From: Michael Eastham
Sent: 11 December 2020 10:32
To: Planning Scanning
Subject: FW: A/166/20/DOC - Manor Nursery, High Street, Angmering

Please see the email below which is the consultation response from the ADC Drainage Engineers to discharge of condition application **A/166/20/DOC** relating to Manor Nursery, High Street, Angmering.

1. The impermeable areas plan supplied does not clearly show the areas draining to each soakaway. E.g. the areas draining to soakaways 8 and 9 are poorly defined. Please can the applicant supply a better impermeable areas plan which clearly shows the areas draining to each soakaway and which areas have had 10% urban creep allowance applied. 60_Network Areas Plan has now been updated for clarity and the drainage areas for SA 8 and 9 is now more clearly defined. The plan also now shows which areas have Urban Creep of 10% applied to them in the key.

FIGURE B.21
TYPICAL INSPECTION CHAMBER DETAIL - TYPE 4 (Flexible material detail)
Maximum depth from cover level to soffit of pipe 2 m, non-entry

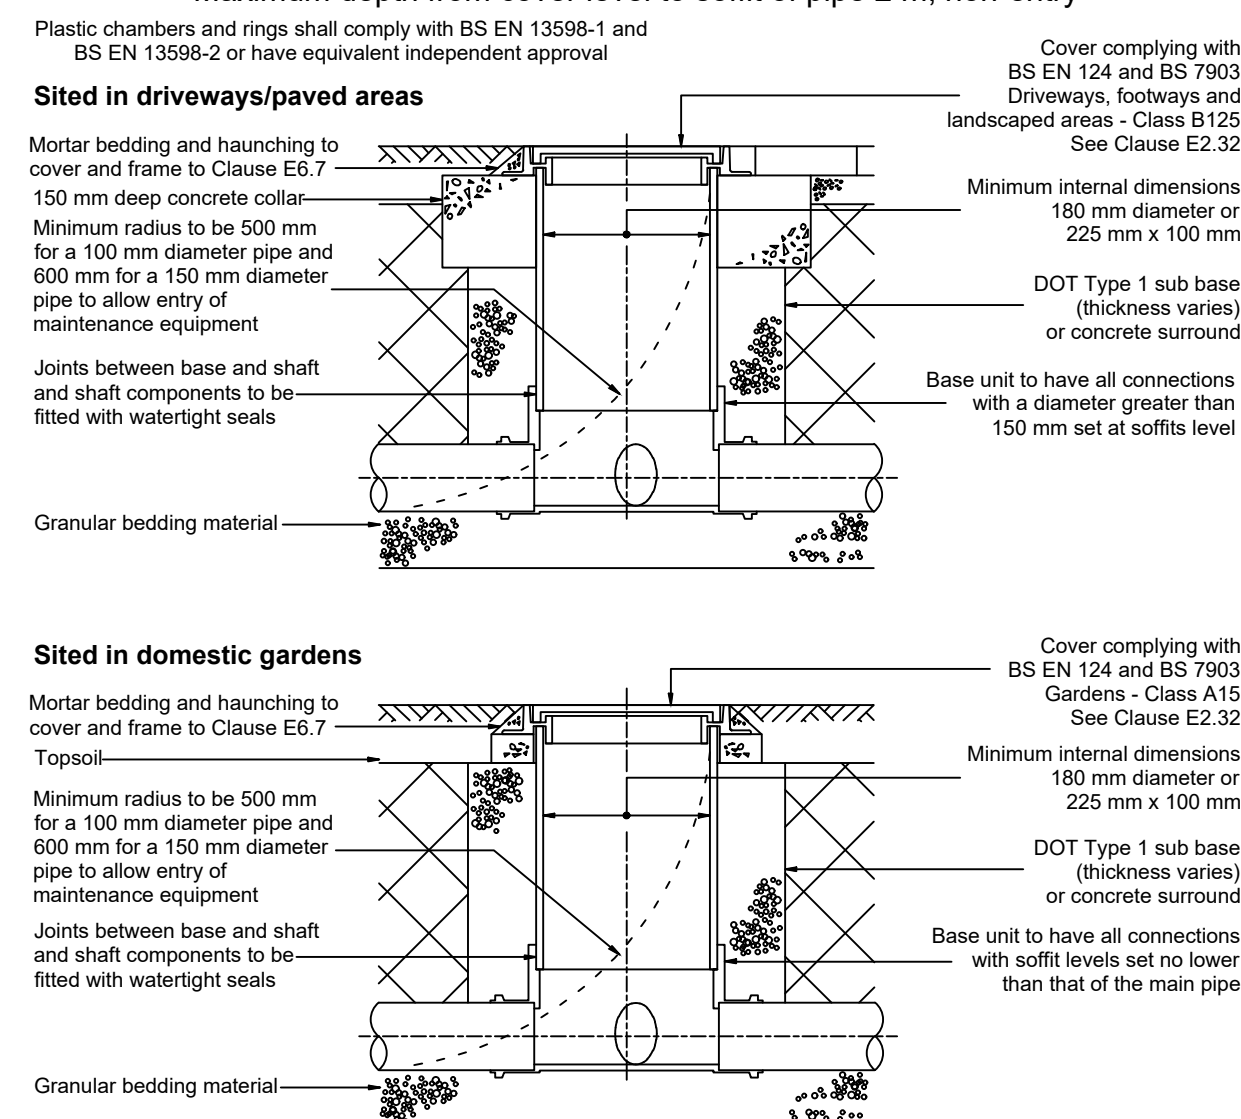
8. The calculation details for SA 7, SA8, and SA9 are different to those on plan. Please correct so that they are consistent. Calculations updated.
9. Construction detail drawings need to be provided, as per our checklist. Please see 502_Construction Details.

CLIENT	Roffey Homes Ltd		
PROJECT	Manor Nurseries Site Angmering		
TITLE	Proposed Drainage Strategy		
DRAWN	DATE	PROJECT NO.	
T Zajac	Mar 2018	22995	
ENGINEER	CHECKED	DWG. NO.	REV.
S Magowan		102	D
SCALE	1:250 @ A1

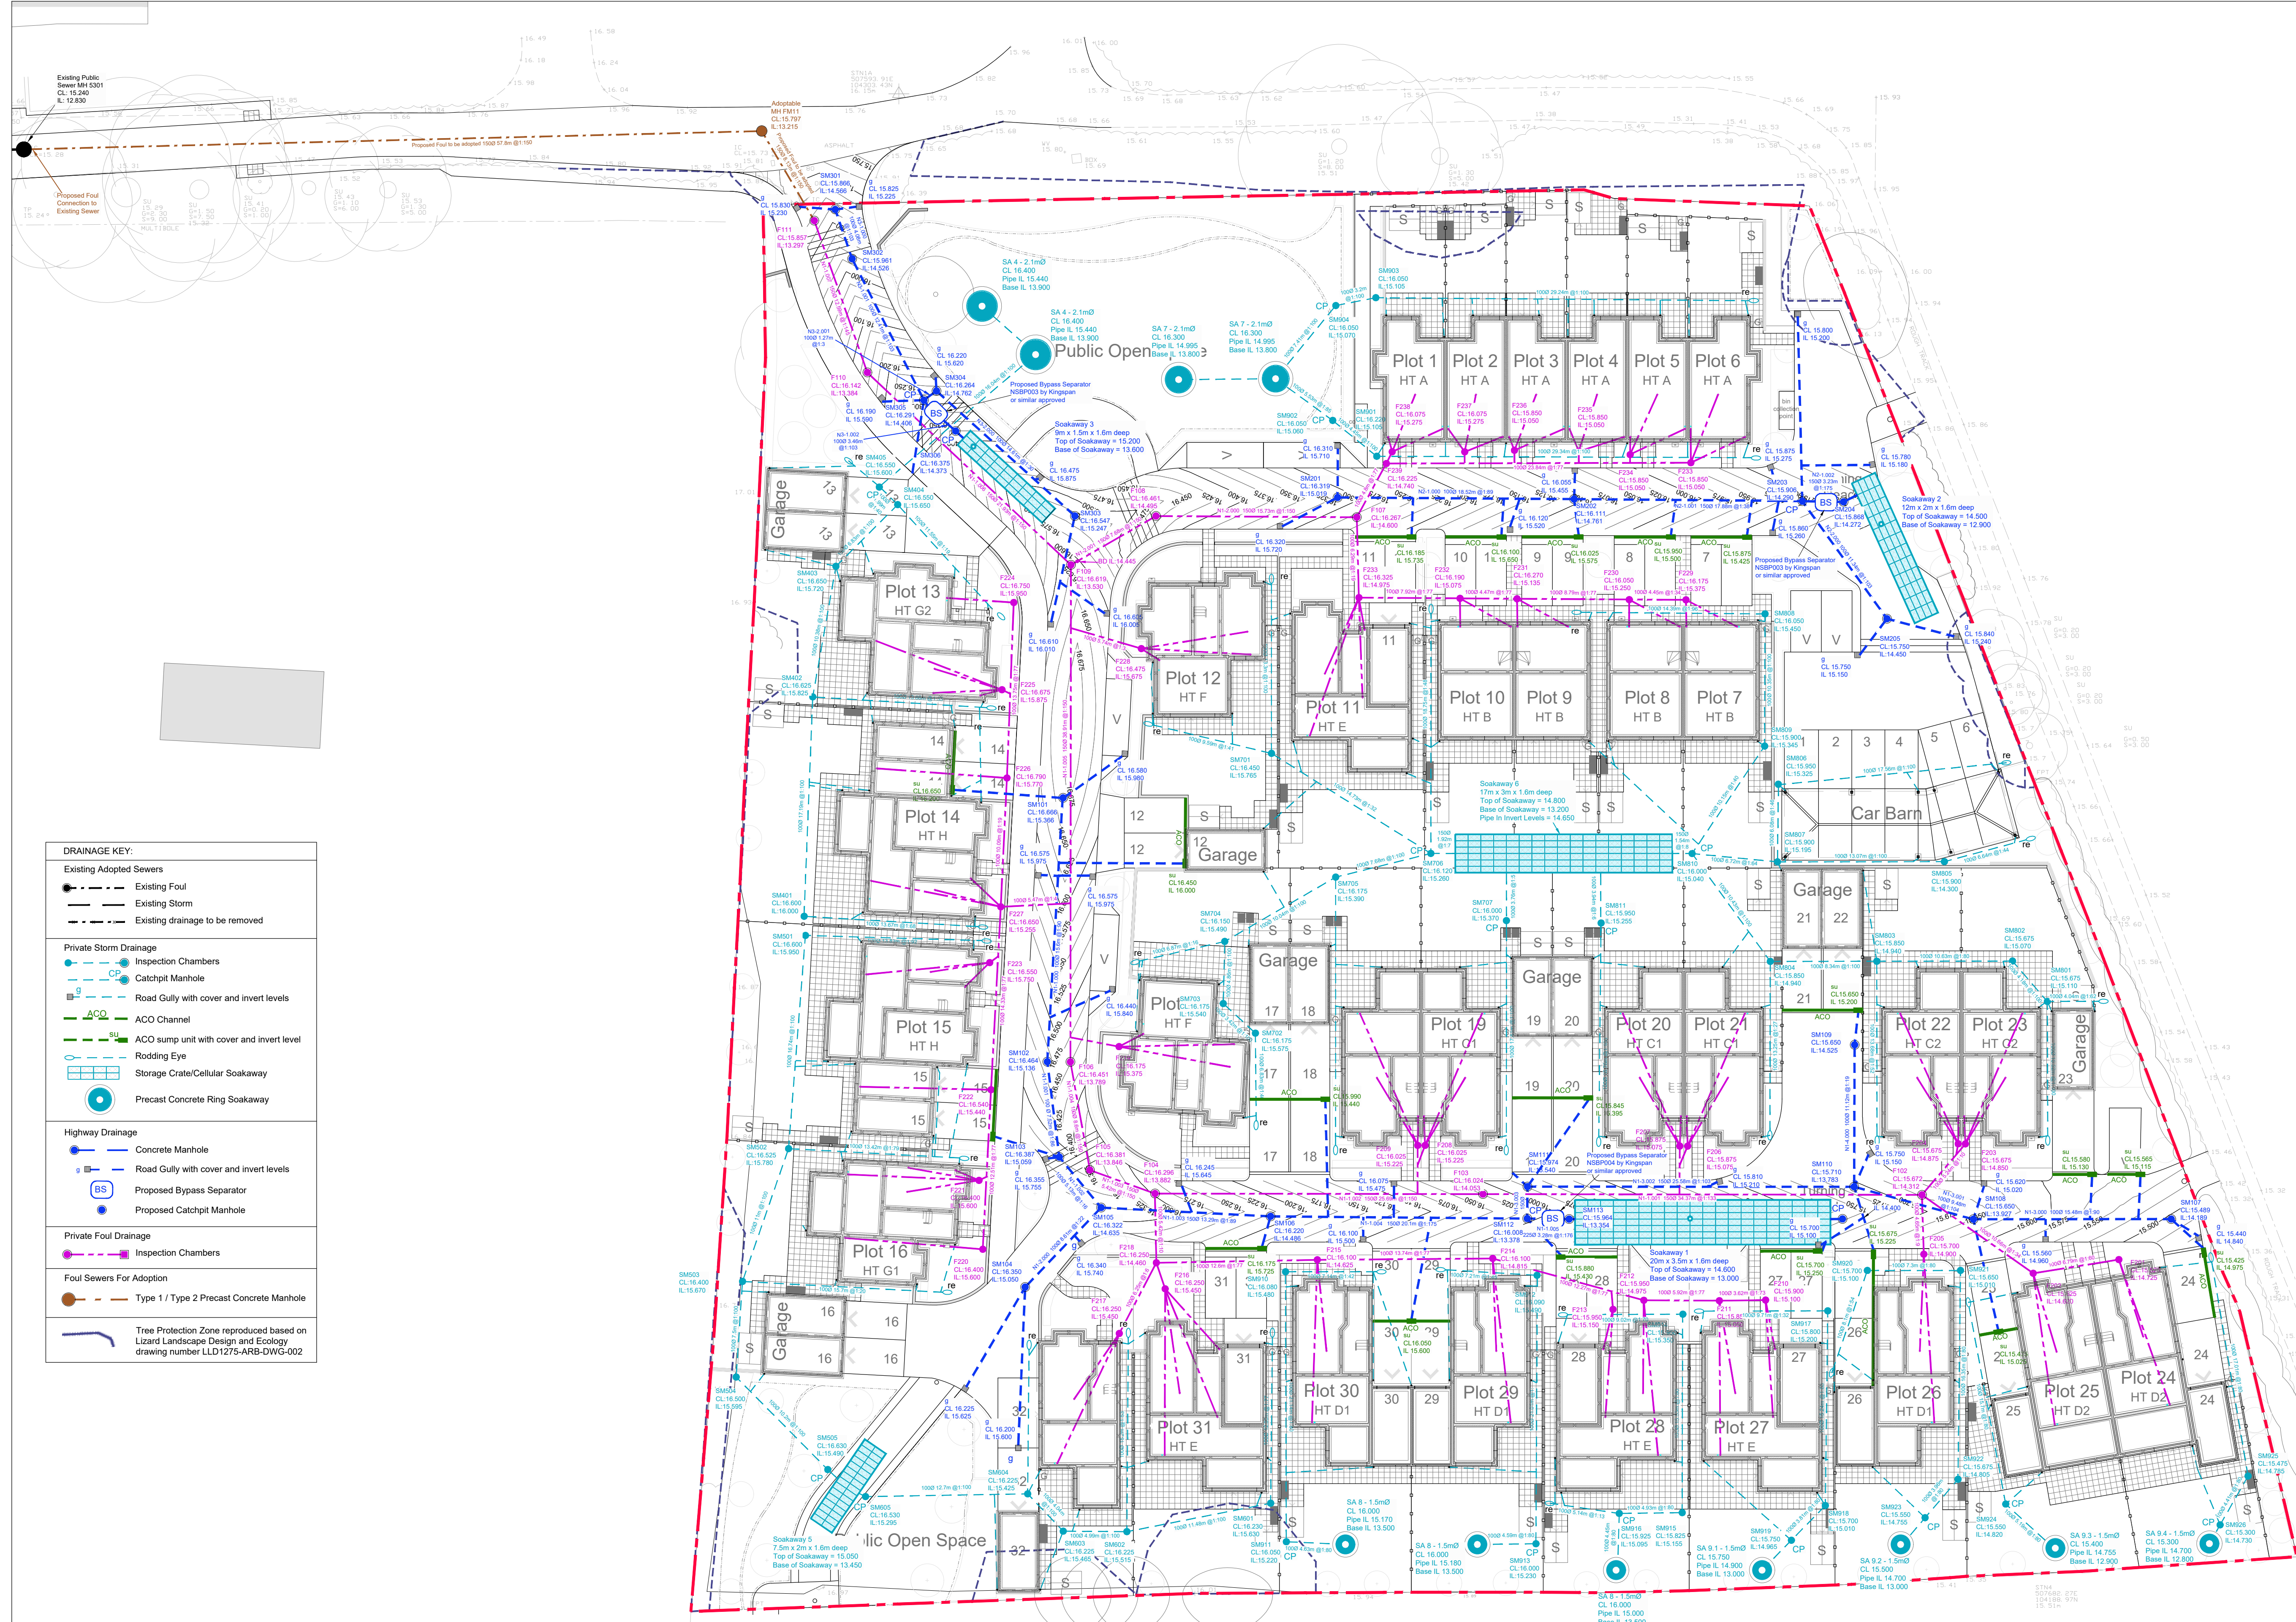
2. Please detail invert and cover levels of gullies and ACO drains. 102_E Drainage has now been updated to include the requested details.
3. Some pipes appear to terminate without connections. For example where are the pipes upstream of N1 2.000 connecting to/from? This was a technical error with the drawing layers and has now been rectified.

5. It is unclear how the pipes that are supposed to be able to pass above soakaway 1 will in reality do this. They are draining surface features, i.e. ACO and gullies, and are meant to pass above the top of the crate which is at 14.6mAOD and then within 1m connect into a pipe that has an upstream invert level of 13.943. Please detail how this is supposed to work especially given some of these connections are not via manholes. The network has been slightly rearranged now in this area and also more details have been included to make it clear how this area works. This has all been checked and there will be no issues with the performance of the network or constructing what is proposed.

7. SA4 has a maximum water level of 16.575, this is greater than the cover level stated on the drawings. The calculation details for SA 4 are different to those on plan. Please correct so that they are consistent. Cover level updated with calculations.

**NSBP003 – NSBP006 Class 1 Bypass Separator
Installation & Operation Guidelines**

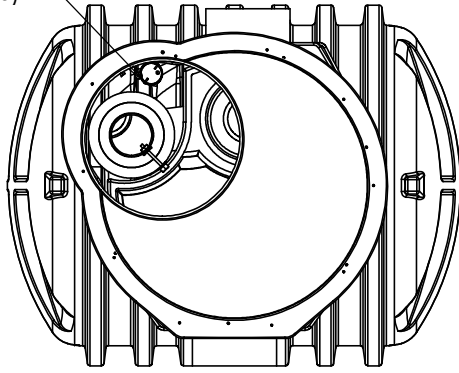
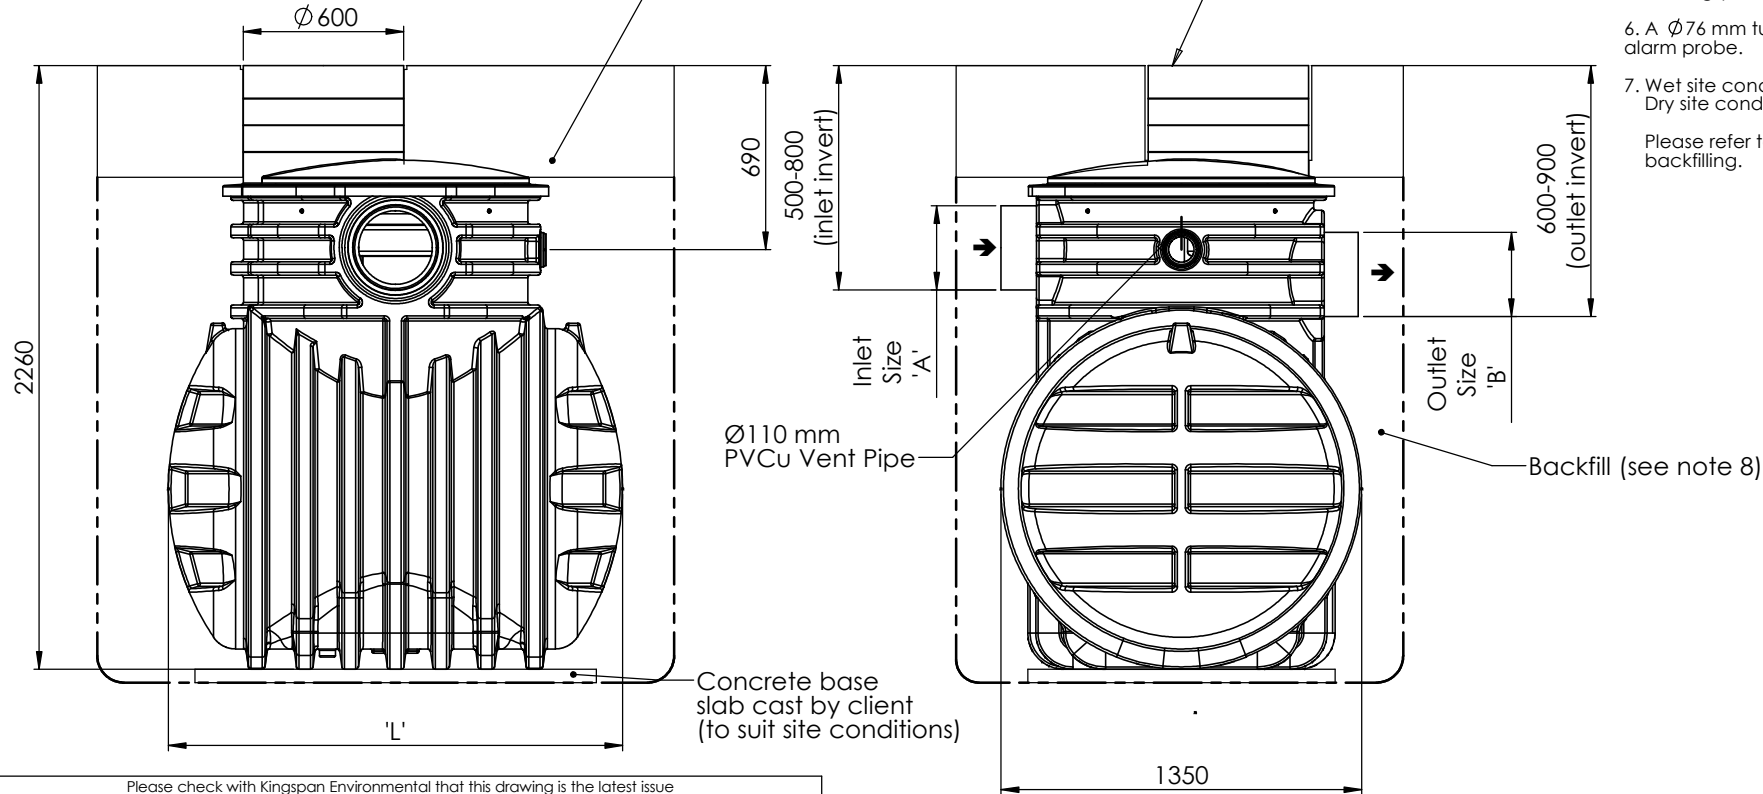
4. Please provide details of the proposed bypass separators and how these will meet the requirements for hazard mitigation indices. Please see attached data sheets and Declaration of Performance.
